**From:** Biazar, Shahab  
**Sent:** Tuesday, November 08, 2016 8:15 AM  
**To:** Michael Balaskovits  
**Cc:** Velarde, Rebecca; Black, Joan; Lubar, Suzanne G.; Carrillo, Abiel X.; Williams, Brennon  
**Subject:** First Flush for One Central (K14D109)

**From:** Carrillo, Abiel X.  
**Sent:** Monday, December 05, 2016 4:30 PM  
**To:** 'Michael Balaskovits'  
**Cc:** Cherne, Curtis; Biazar, Shahab; Daggett, Kevin; Romero, Ron; MacKenzie, John  
**Subject:** One Central - K14D109

Based on information provided in your submittal dated 11-1-2016, the above-referenced Grading and Drainage plan cannot be approved for Foundation Permit. See comments below:

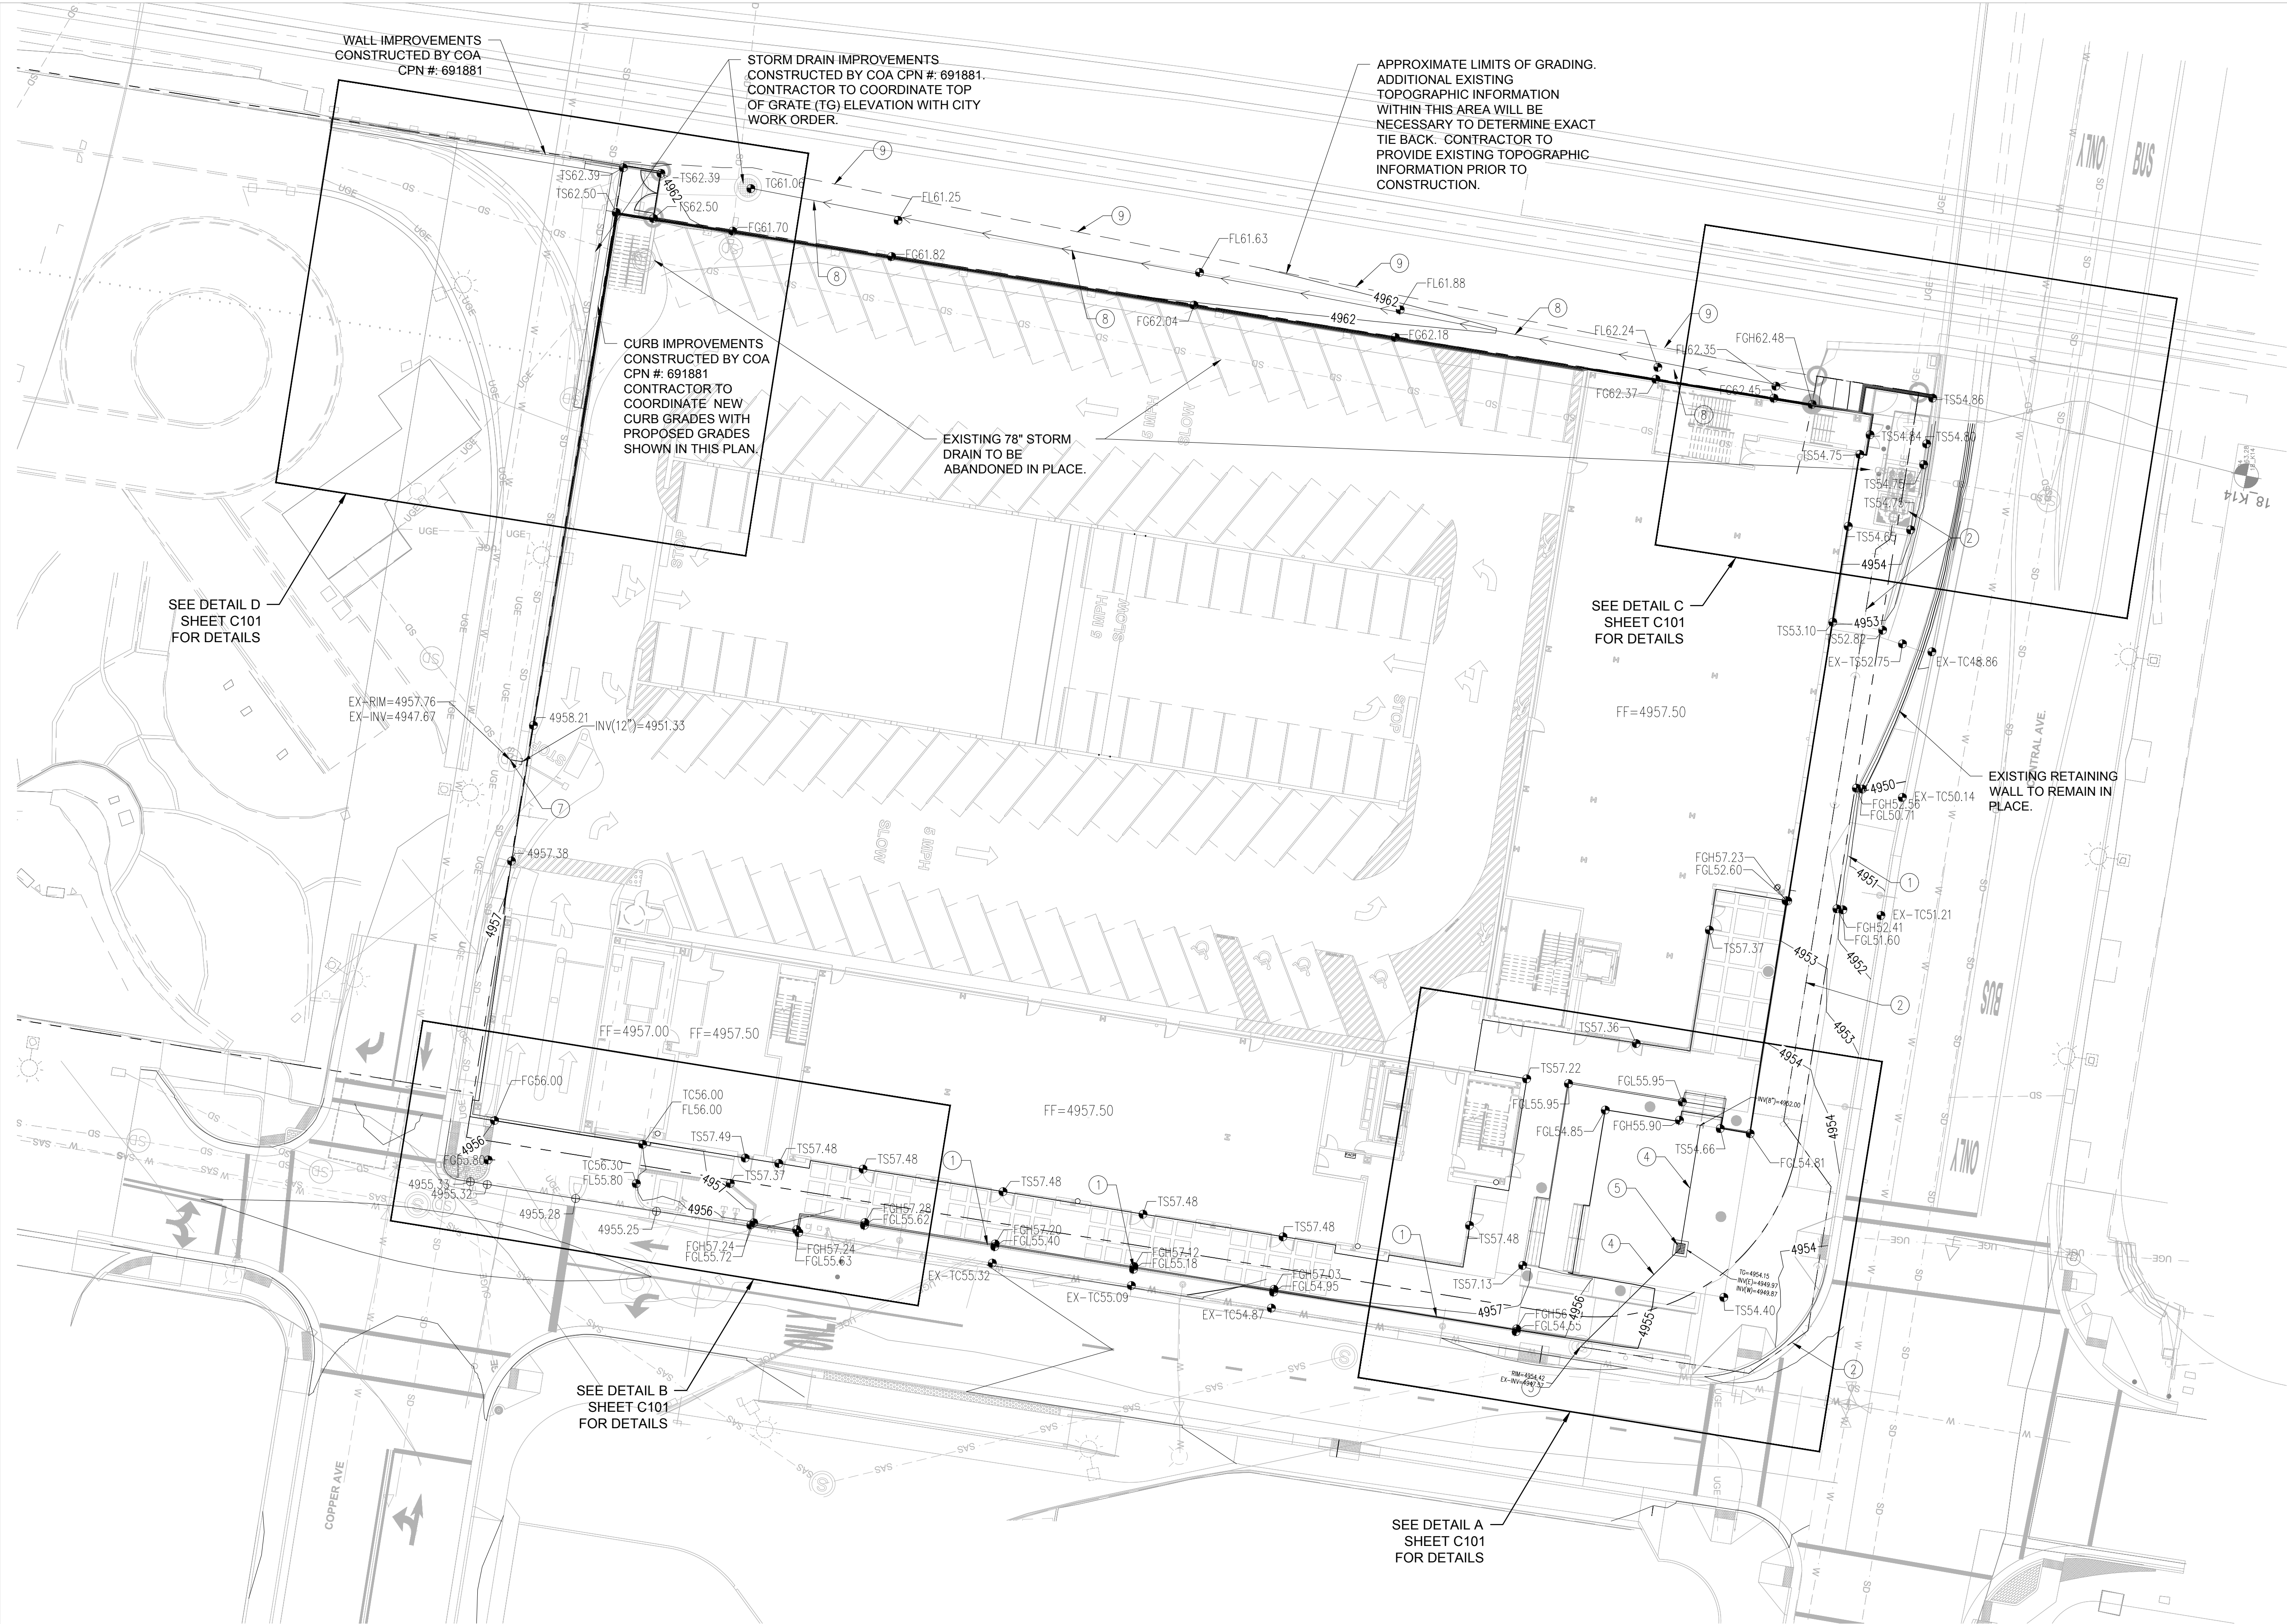
2. The plan needs to specify how the storm drains that will be placed under the building will be treated (capped, lean filled, etc).

4. There is a storm drain shown as existing along the western wall of the future building. It is not clear that the line exists.

5. Per previous meetings, the area between the future building and the NMRX Right of way needs to be graded to drain to the north, where an inlet needs to be purposed to accept runoff from that strip (and from the Railroad right of way?). The work will likely require access permits from the NMDOT Rail Section.

6. DMD is planning some storm drain realignments under the future northeast corner of the building. Construction of the foundation would presumably need to occur after the realignments are complete.

7. The northern frontage of the parking lot structure will be within the trench prism of the 48" Storm Drain under Copper.

8. DMD will not allow the roof drains of the building to be directly connected to the Copper storm drain line. A significant portion of the building and parking structure will be discharging to the north. Assuming the grades work, can this discharge tie directly to the new manhole configuration being proposed with the DMD proposed realignment at the northeast corner in lieu of the existing manhole tie in? Why exactly is this connection not allowed?

Please see attached for the updated grading plan that address what is being proposed for the existing 78" storm drain. We are working with the sub contractor to determine what exactly they will determine as a means to fill in this pipe and show it accordingly. The existing 78" line has a manhole in close proximity to the NE corner of the site, which will have to be removed with the rest of the line under this task. DMD wants a new manhole to be replaced just north of where the pipe fill line will terminate so that access to the remainder of the line to the north can be maintained.

This was cleared up during the phone call. The line no longer exists along the west boundary of the property, as it was remove with our construction.

The City will obtain a license from DOT for the installation of new storm drain around the NE corner of the One Central site. Anything south of this new line and its manhole within DOT R/W will have to be licensed by DOT to the developer. After raising grade along the west side of the tracks and getting local runoff to drain north, the manhole being installed by DMD can collect the estimated 1 cfs via a grated inlet cover on the MH.

Understood. We will need to coordinate directly with DMD to understand what exactly these improvements are and who is responsible for what. We would like include these improvements on these plans so all are on the same page if possible similar to the pump and force main along the south side. The DOT license is routing for signatures. The plans for the new SD are still in design and they won't be finished for several weeks. When finished they will have to be routed with the License to the DOT for review and approval.

that the developer conduct an evaluation of the potential impact on the existing storm drain from the new building foundation, and certify based upon the evaluation that there will not be any adverse impact on its integrity.

We don't have any objection to the roof drains on the north side of the building discharging directly into the existing Copper storm drain as it's shown on the plans.
